The property at 63 Revere Street in Portland is presently for sale. The property has been leased as four dwelling units for some time, but the fourth dwelling unit was not approved by the City of Portland and no Certificate of Occupancy exists for the last unit. The fourth apartment was built before 1978 by Ms. Goodie's father.

Ms. Goodie then applied for acceptance of the fourth unit in 2013. The following conditions were observed:

REAR VIEW

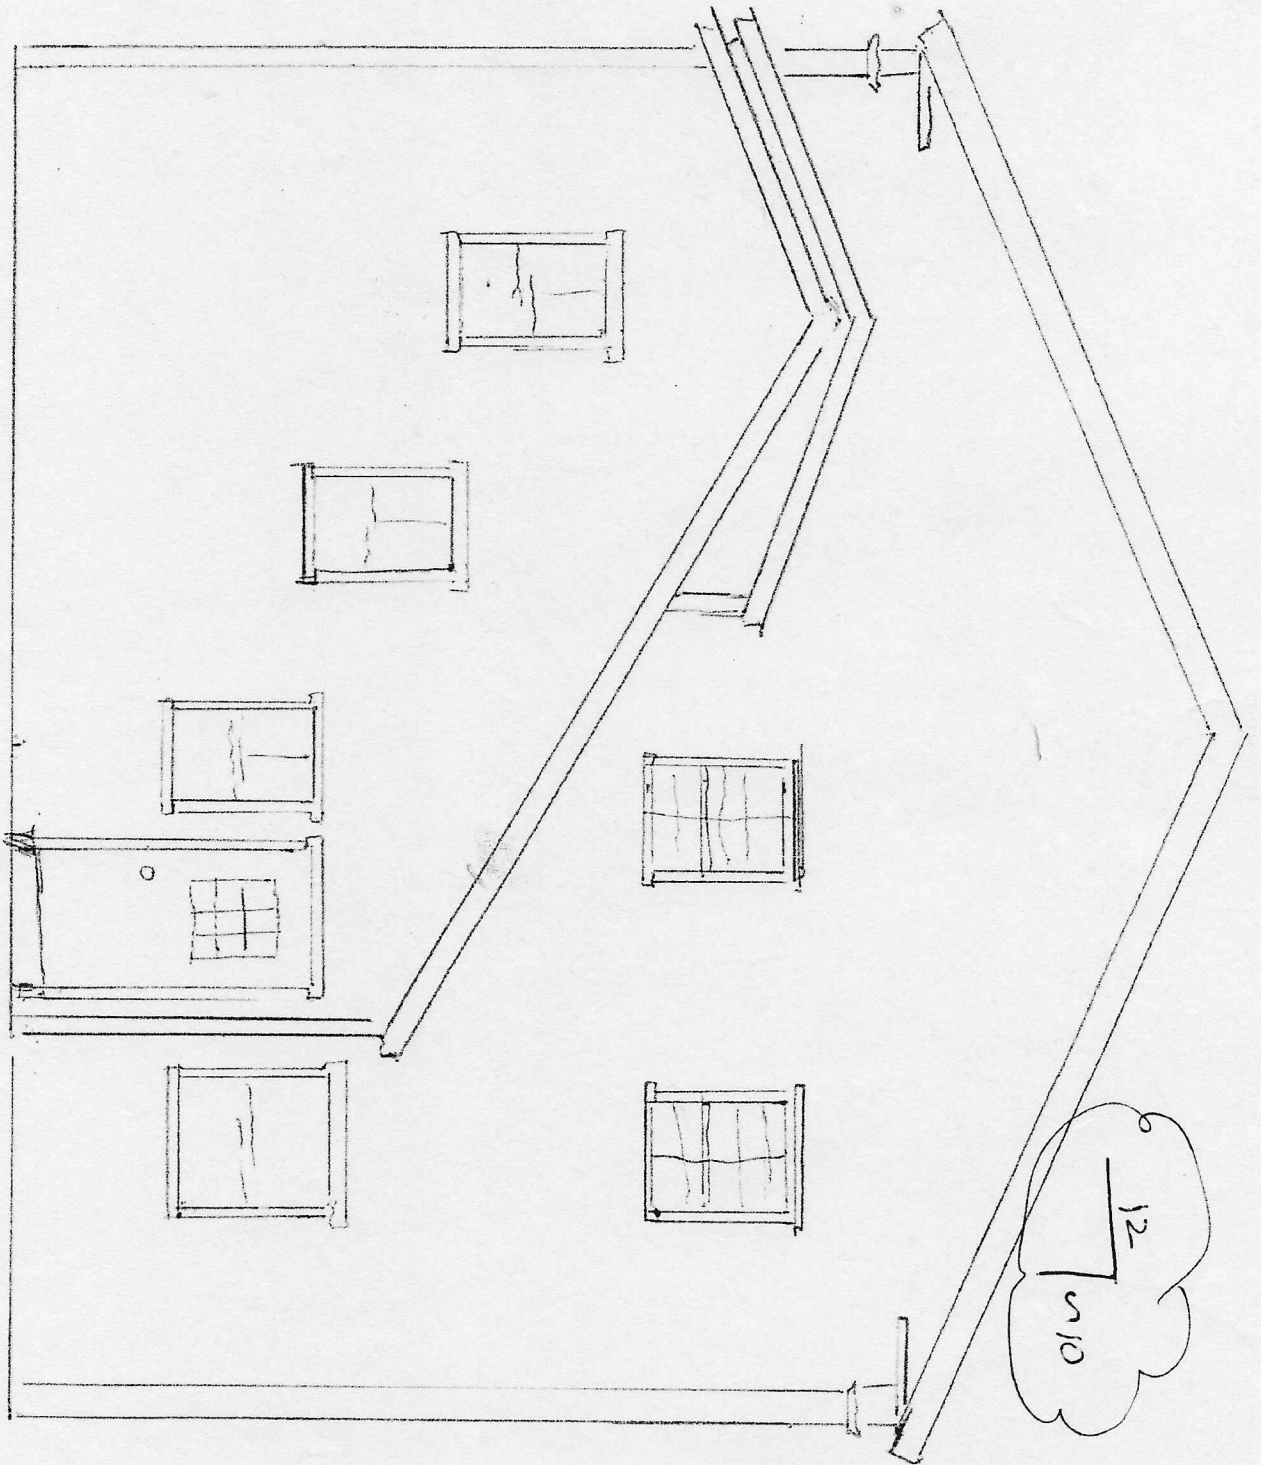
- Exterior deck unsafe NTC
- Rear exterior rail not secure
- Interior spiral staircase NTC Not safe
- Illegal unit must adhere to NEC 2011
